Department of Planning and Environment

Our ref: SSD-31552370

Subject: Raymond Avenue Warehouse, Matraville (SSD-315523370) Request for Additional Information

Attachment 1 Department of Planning and Environment Comments on EIS

Site Operations – Day (Mitigated)

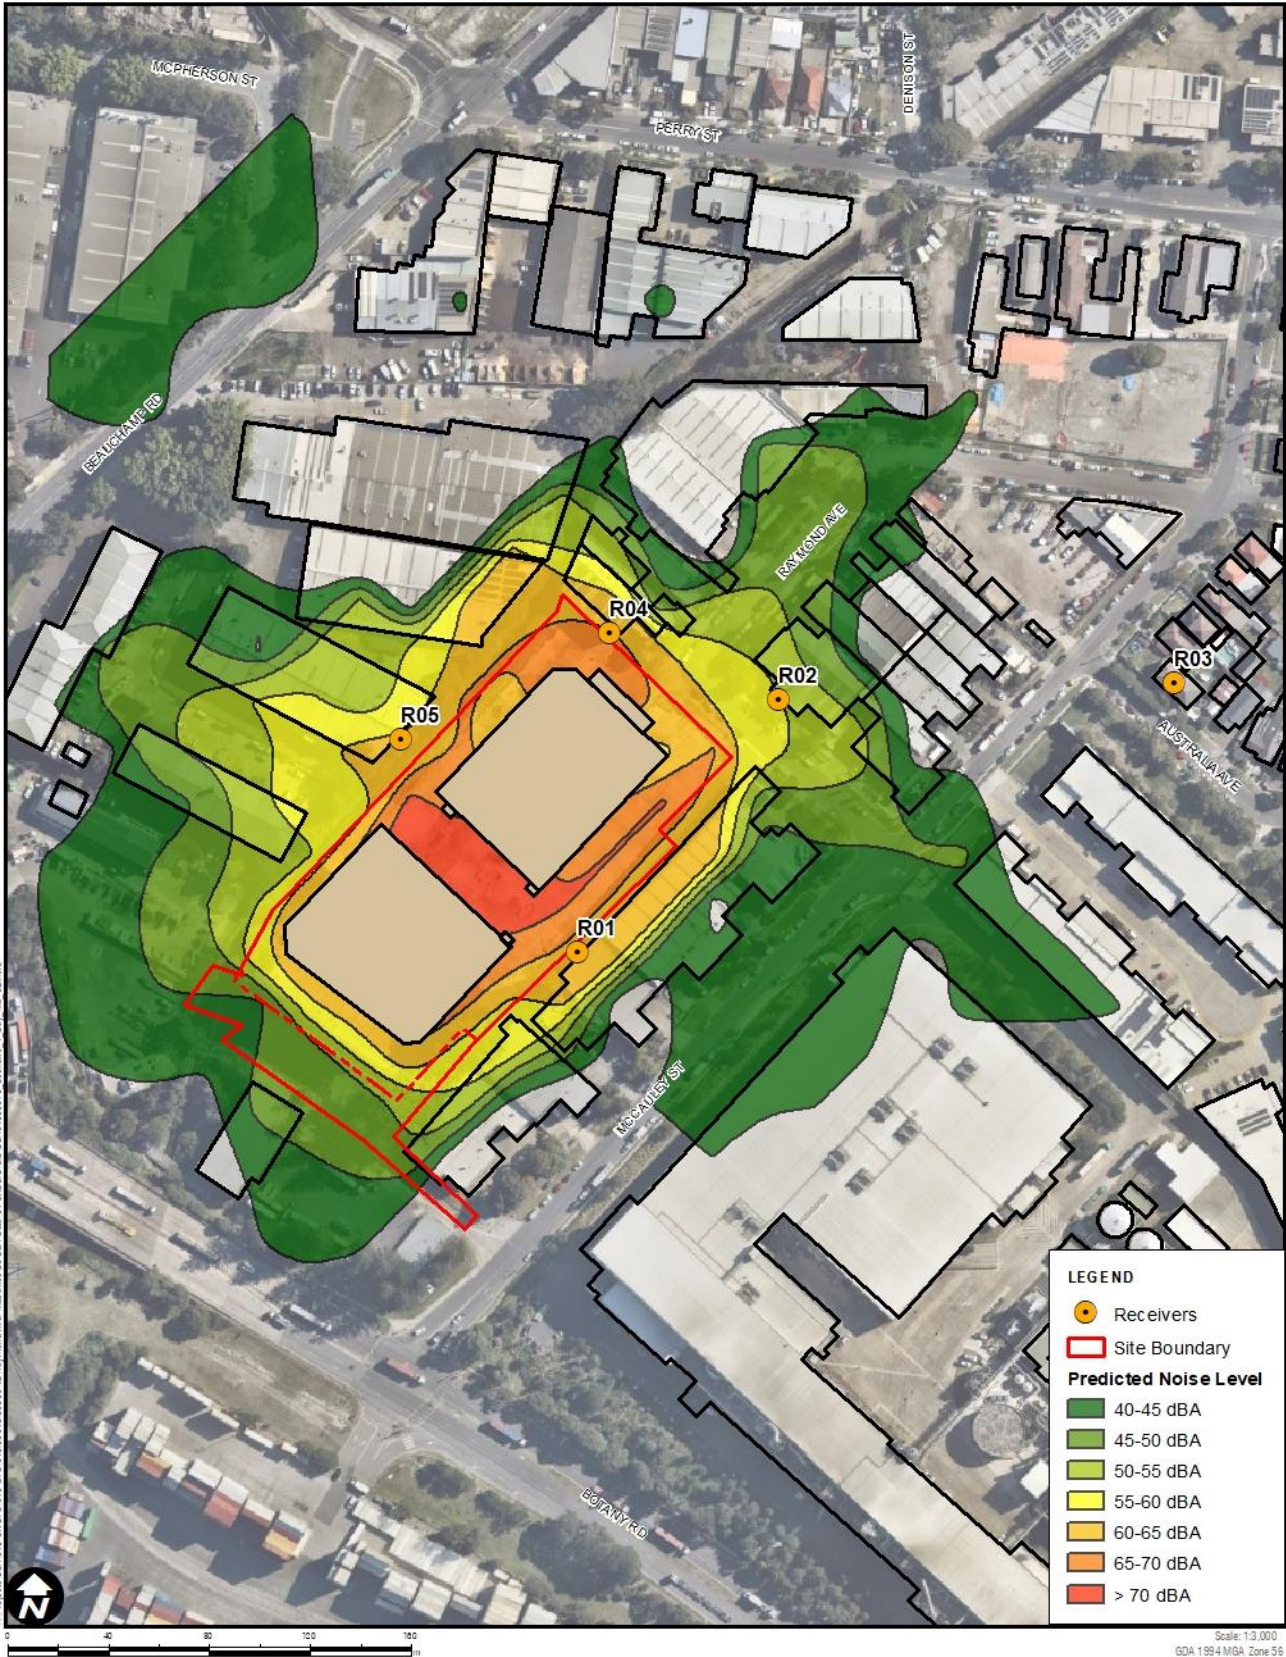
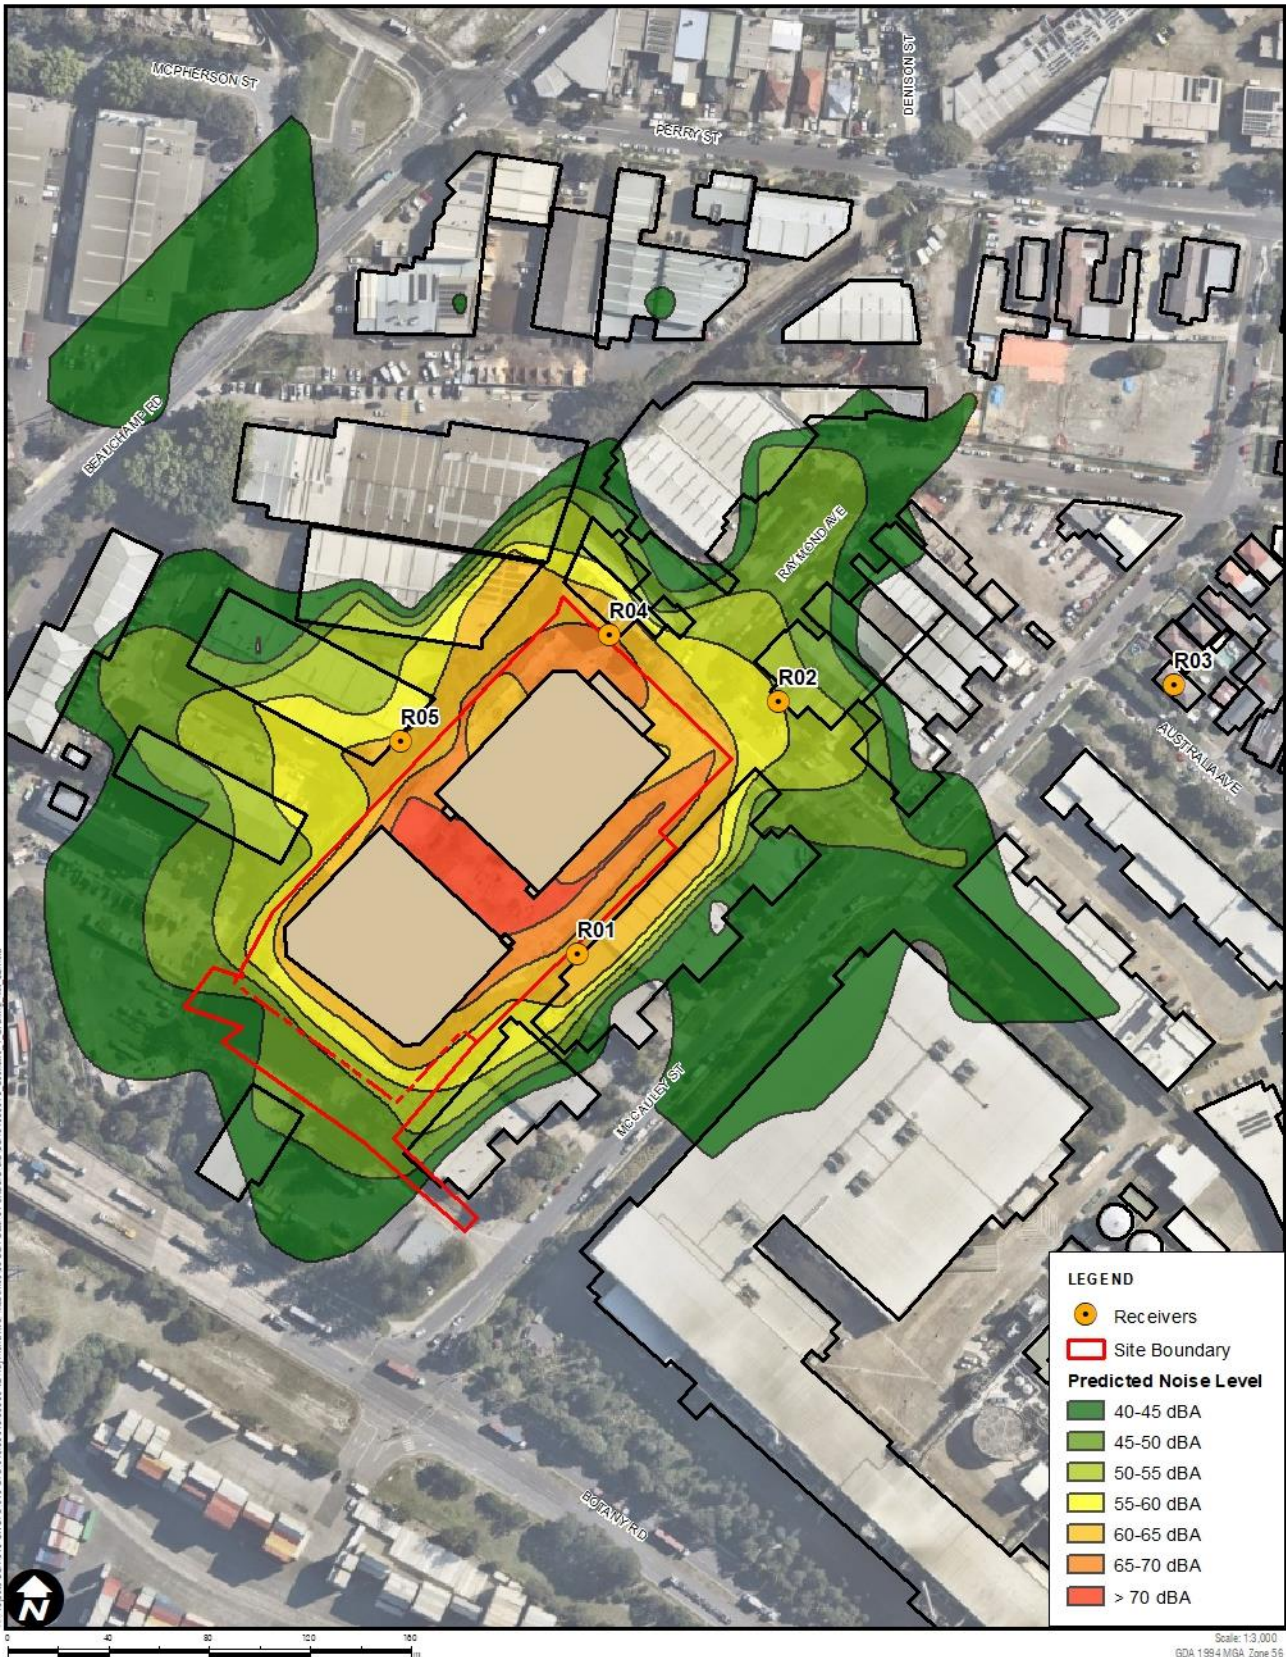
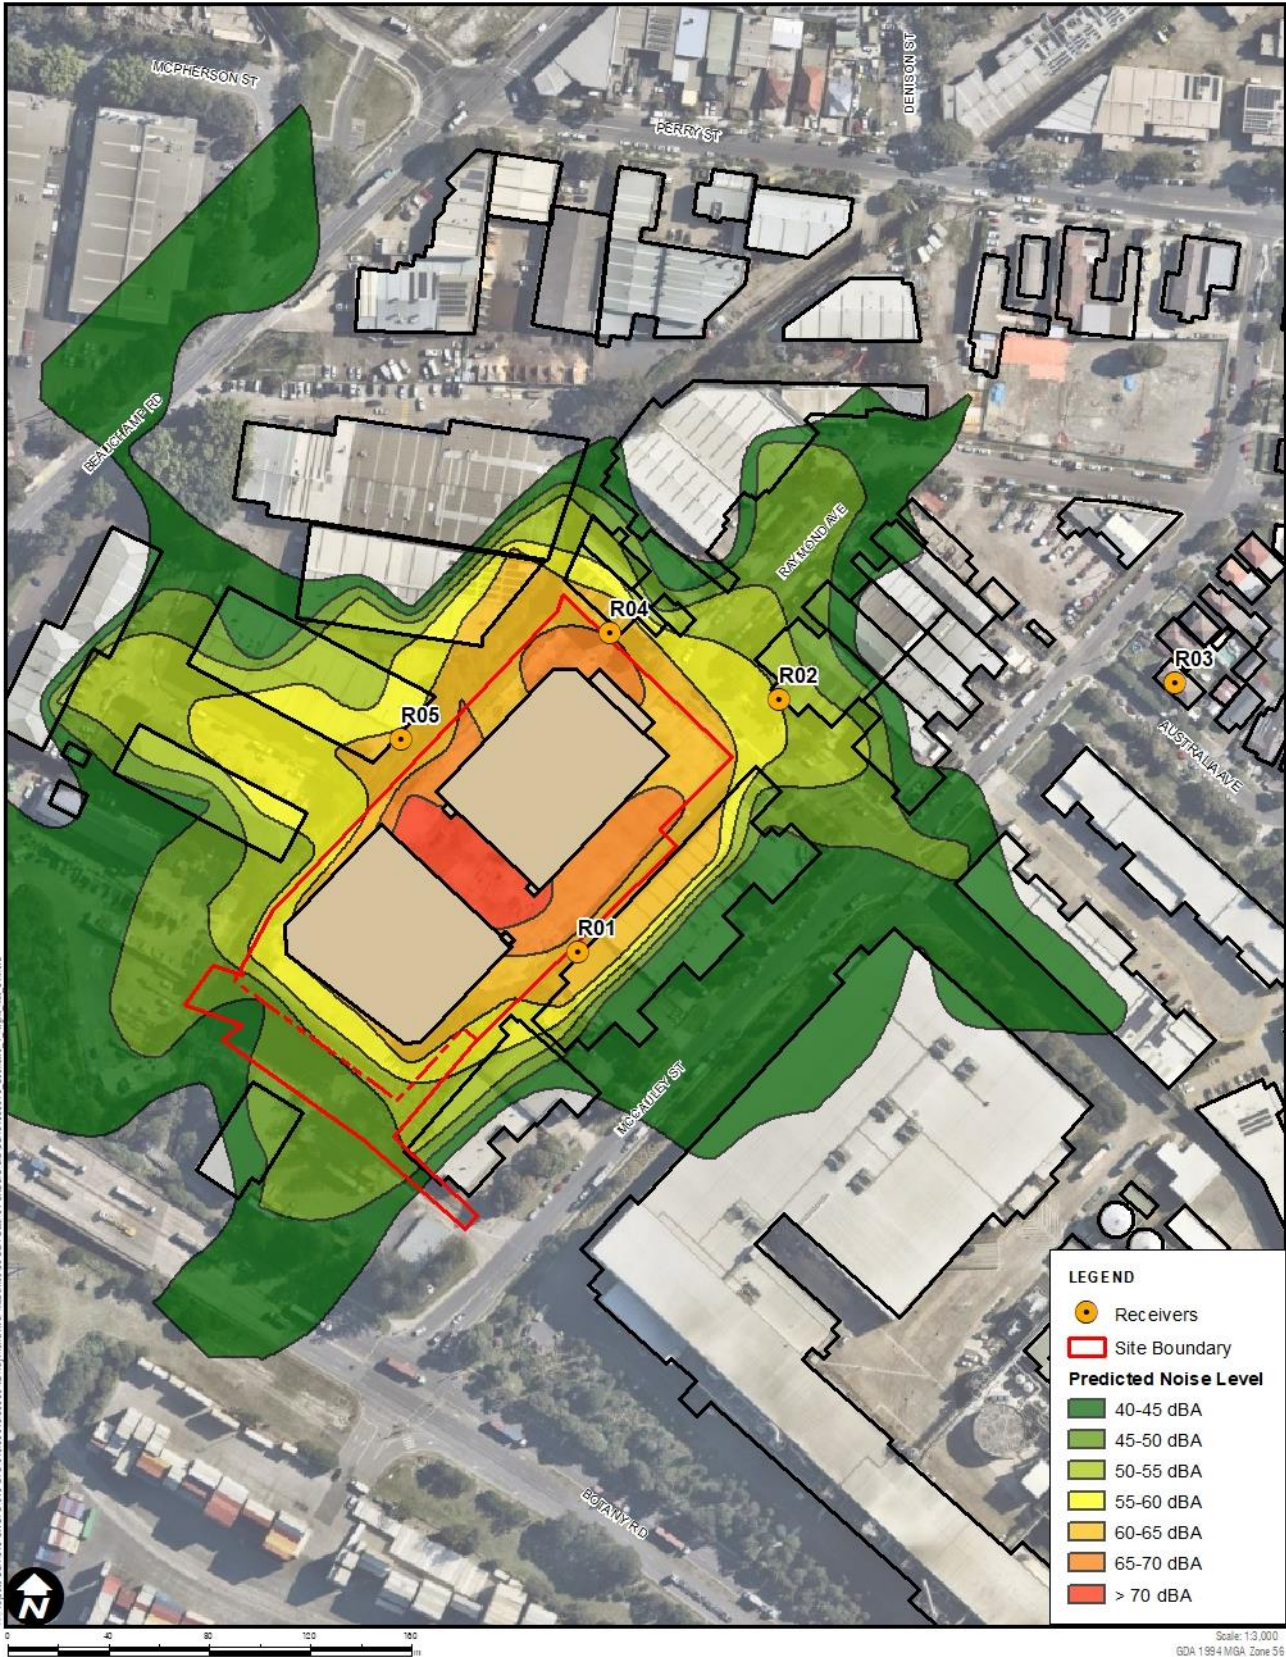
10. The potential increase in traffic noise is cited as a source of noise concern by residents living in close proximity to the subject site. The TIA details night-time exceedance for receiver R03 caused by a combination of noise from the roof mounted fans, on-site truck movements (hardstand) and loading activities. Further clarification is required to verify if the accelerating and decelerating articulated vehicles and small rigid trucks, as they utilise the key access ramps to level one, have been included as a night-time source.
11. Additionally, feasible and reasonable noise mitigation measures such as at-property treatments along the access ramps may be required to minimise night-time noise impacts.

Figure 22: Construction Vehicle Routes

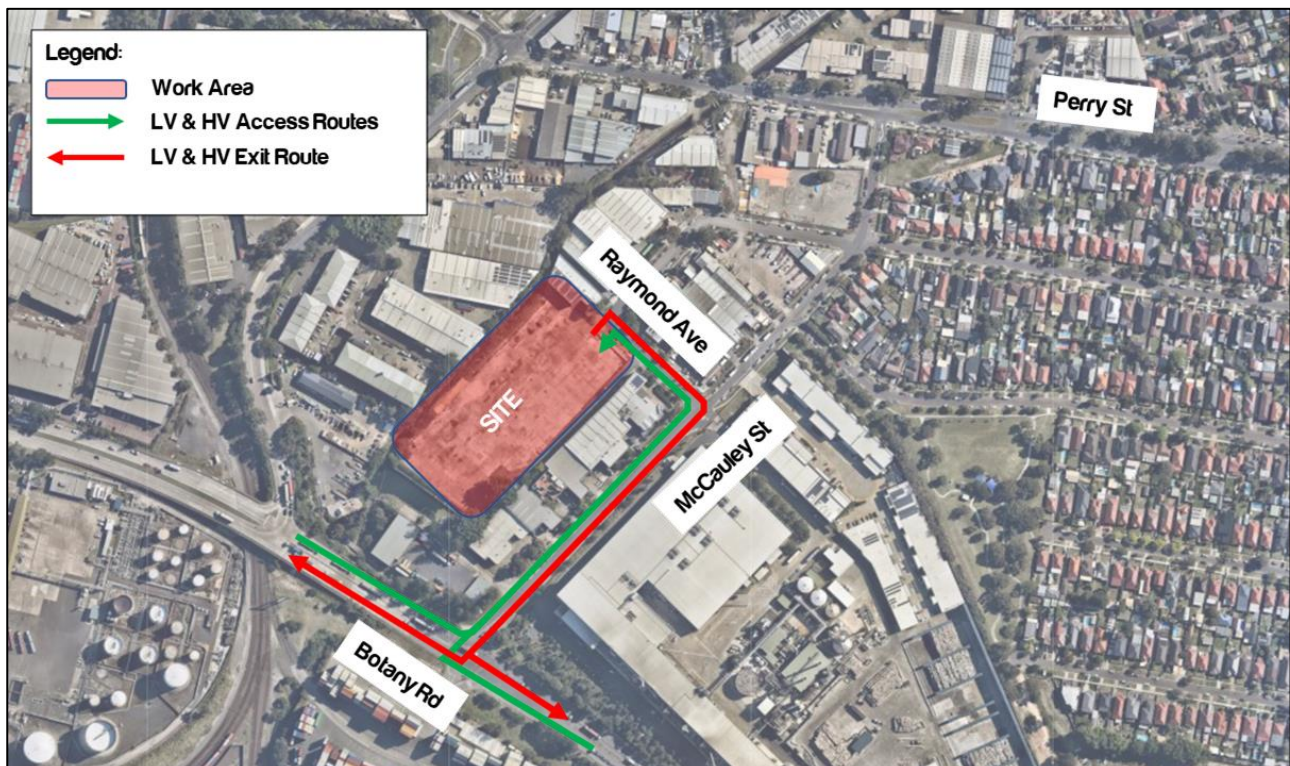
7. Update the information presented in Part 4.3.3 of the TIA to show passenger car equivalent units and a breakdown of vehicle of the expected traffic generation for each scenario over a 24-hour period.
8. In addition, the EIS and TIA do not provide any commentary regarding how the proposed shared access arrangements would mitigate conflicts between cars and heavy vehicles.
9. Part 9.3.5 of the TIA indicated construction workers will be able to park on the site as parking areas become available, plans of this proposed staged parking arrangement is required. It is unclear where construction workers will park their vehicles prior to the establishment of parking areas or after these areas are no longer available. If off-site, describe how construction workers will be transported to site.
